From: Sarah Jolley [REDACTED]
Sent: 06 July 2022 10:55
To: Planning.Responses <Planning.Responses@arun.gov.uk>
Subject: RE: Planning Consultation on: BN/65/22/PL

At a meeting of Barnham and Eastergate Parish Council Planning and Environment Committee Meeting on 21 June, the committee resolved to submit an objection to this application. The Committee's reasons for their objection are as follows:

Application No:	BN/65/22/PL
Registered:	7th June 2022
Site Address:	Land at rear of Cedar End Eastergate Lane Eastergate PO20 3SJ
Grid Reference:	494923 106106
Description of Works:	Sever land and erection of 1 No bungalow with new vehicular access (resubmission of BN/14/22/PL). This application is a Departure from the Development Plan and is in CIL Zone 3 and is CIL Liable as new dwelling.

Proposed Site Plan
1:200

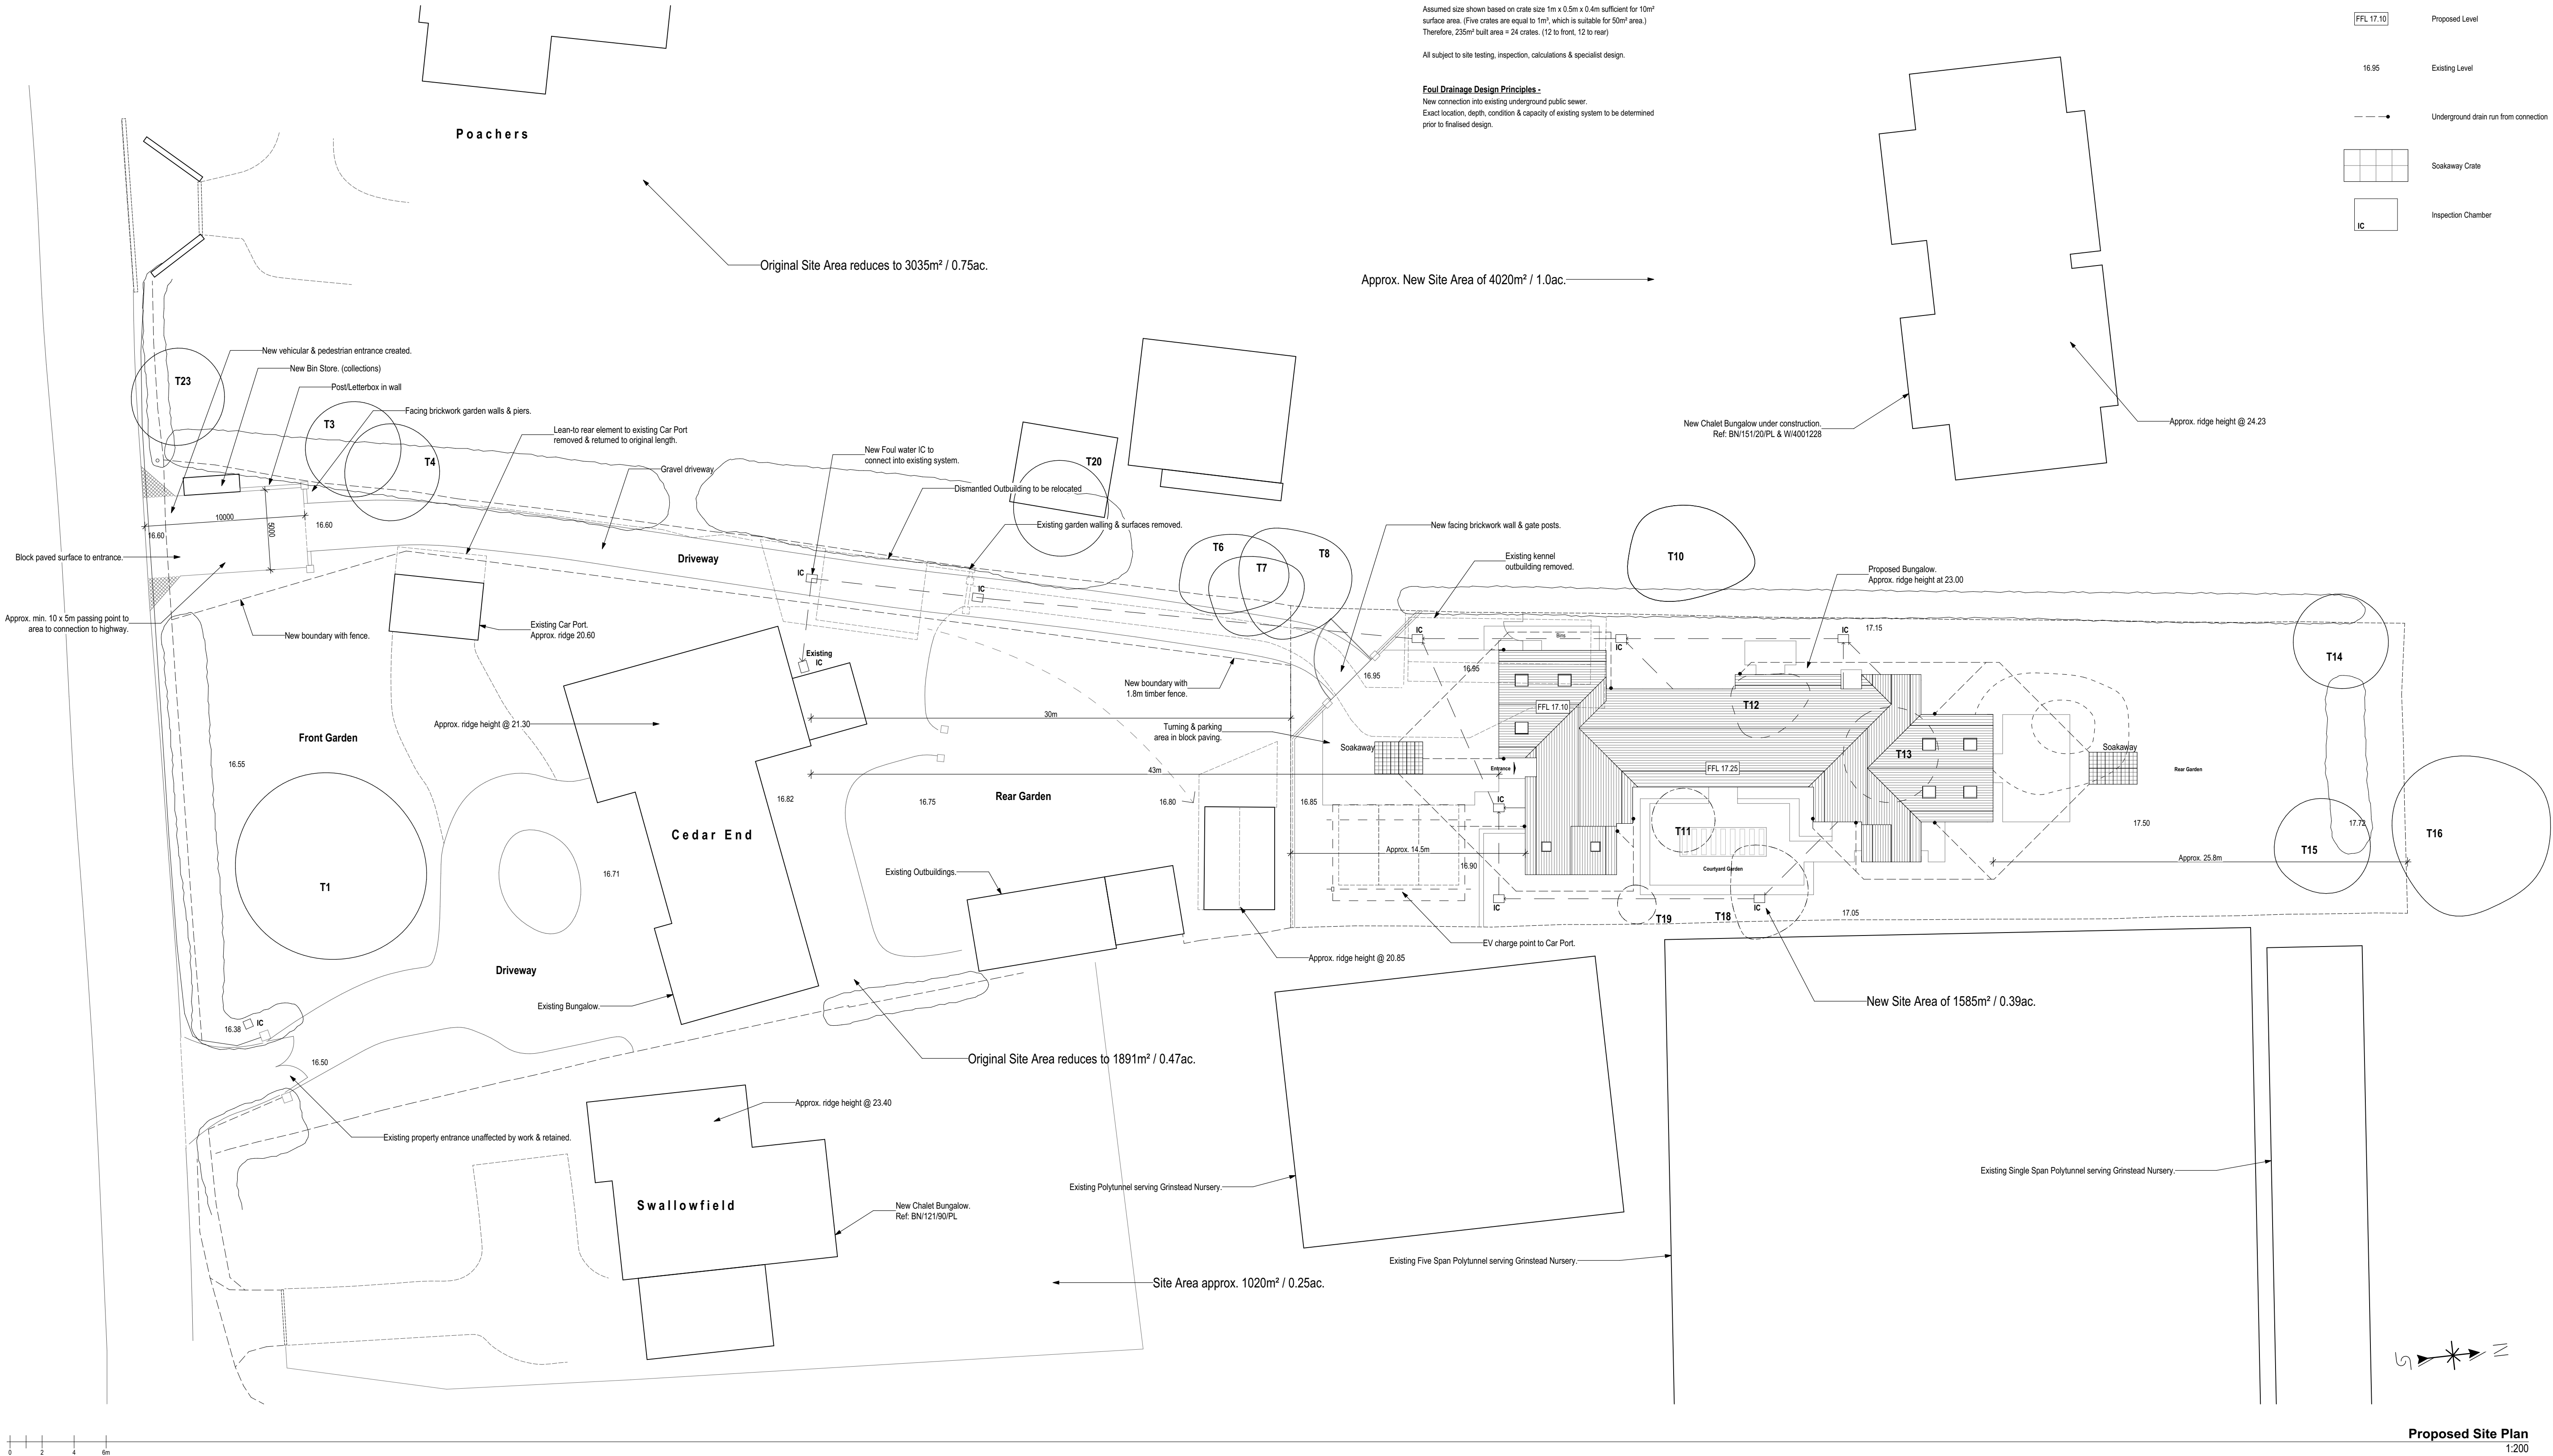
1. It is outside of the Barnham and Eastergate built-up area boundary
2. It is against the following neighbourhood policies:
 - 2.1 **ES1B Reducing Flood Risk-** All development proposals on undeveloped land (i.e. greenfield) must demonstrate that peak surface water run- off rates and run off volumes from the application site will be returned to pre-development greenfield criteria, as far as reasonably practicable. All development proposals on previously developed land (i.e. brownfield) must demonstrate that surface water run-off from the application site as a result of the development will be as close as reasonably practical to the

greenfield run off rates from the development for the same rainfall event but should never exceed the rate of discharge from the site prior to its redevelopment. New and improved utility infrastructure will be encouraged and supported in order to meet the identified needs of the community. Planning permission will only be supported for new development subject to a drainage condition(s) in accordance with ADC standard conditions.

Visibility Splays
1:2000

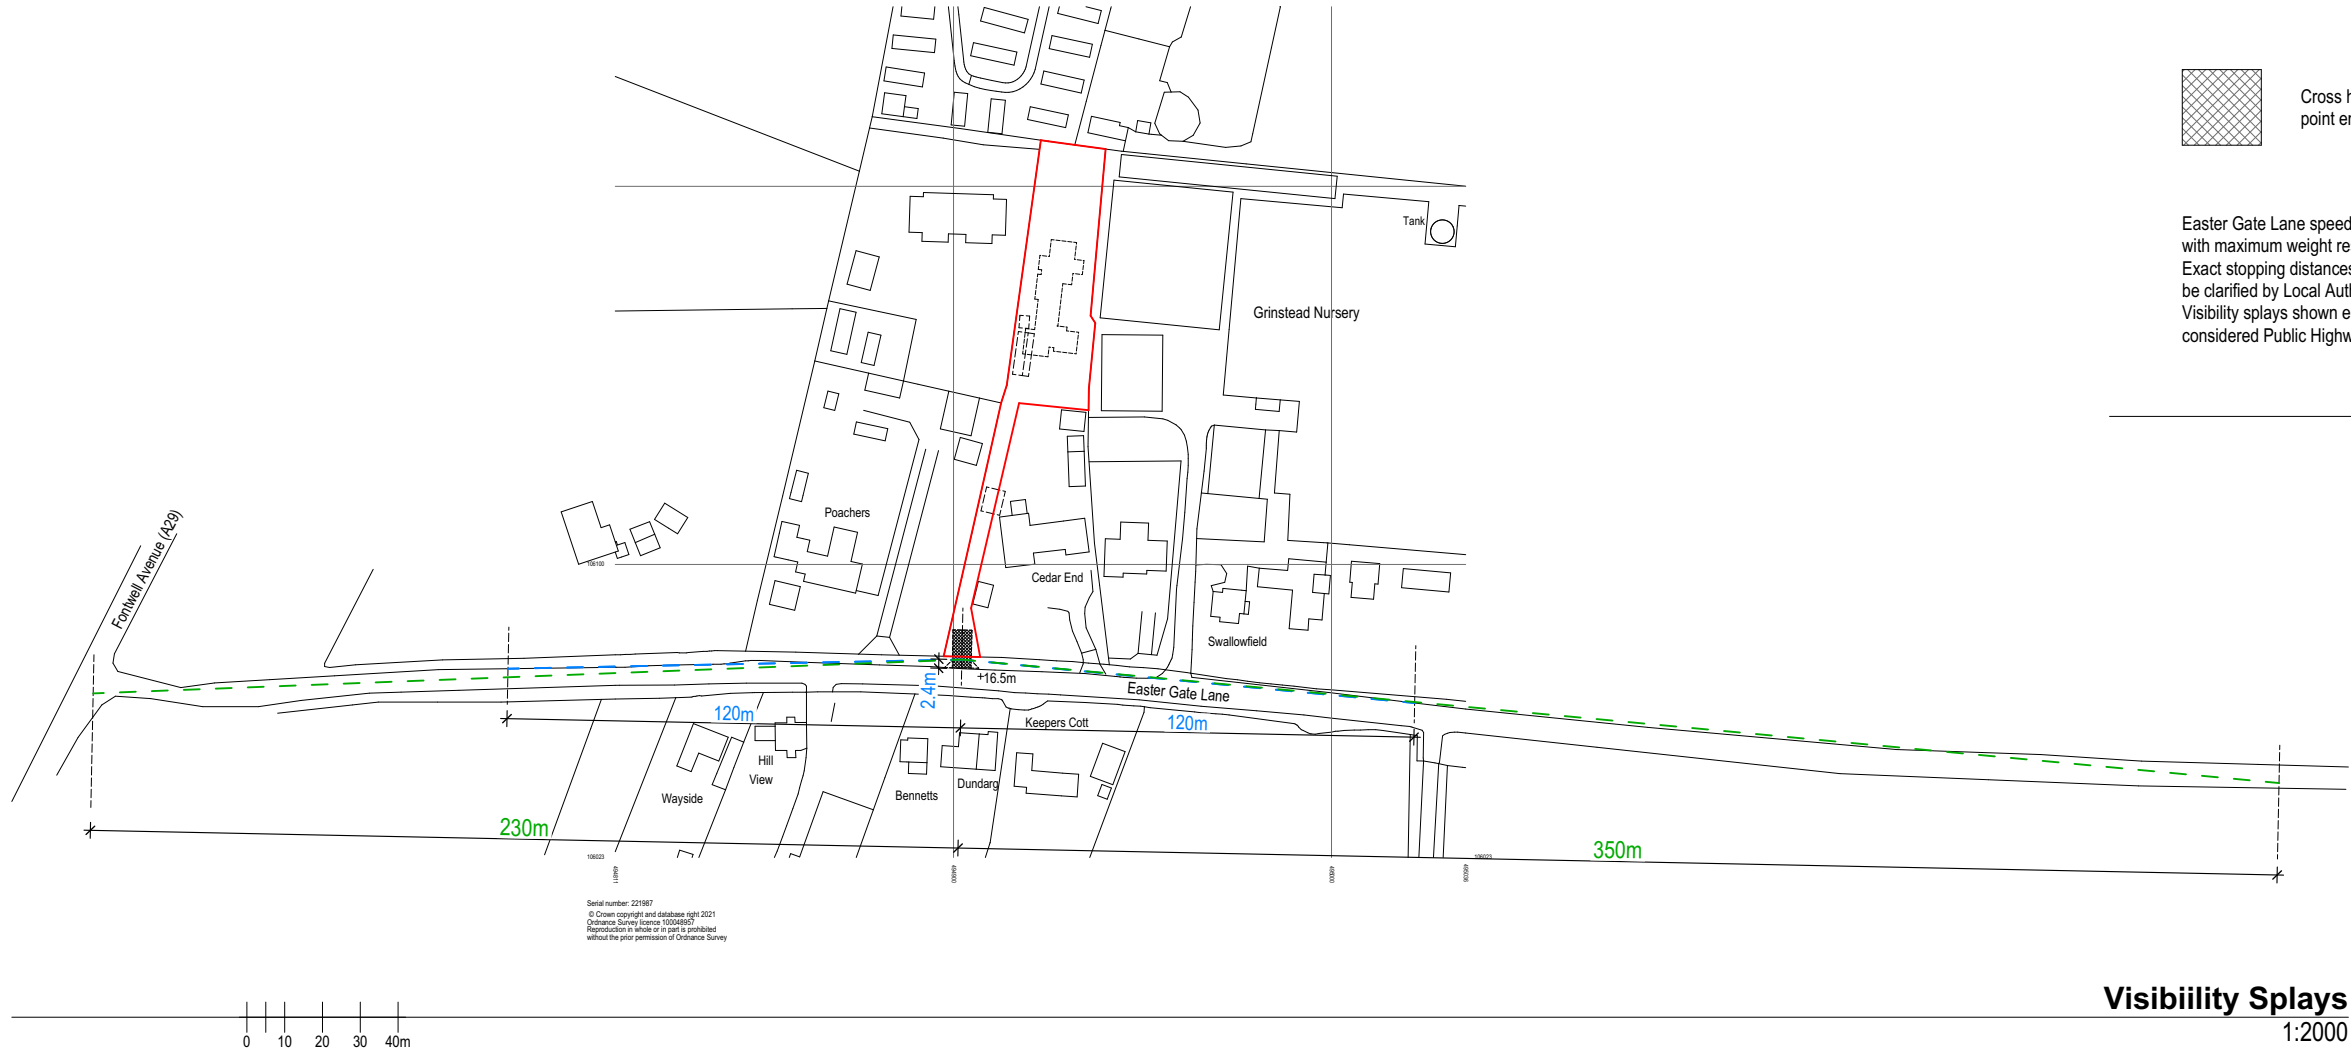
The Committee are concerned about the access and egress to the site and would welcome the Arun Tree Officers recommendations. The Parish Council also noted that they would not like to see any further trees removed in this area and feel that it is critical that all trees are protected in this area.
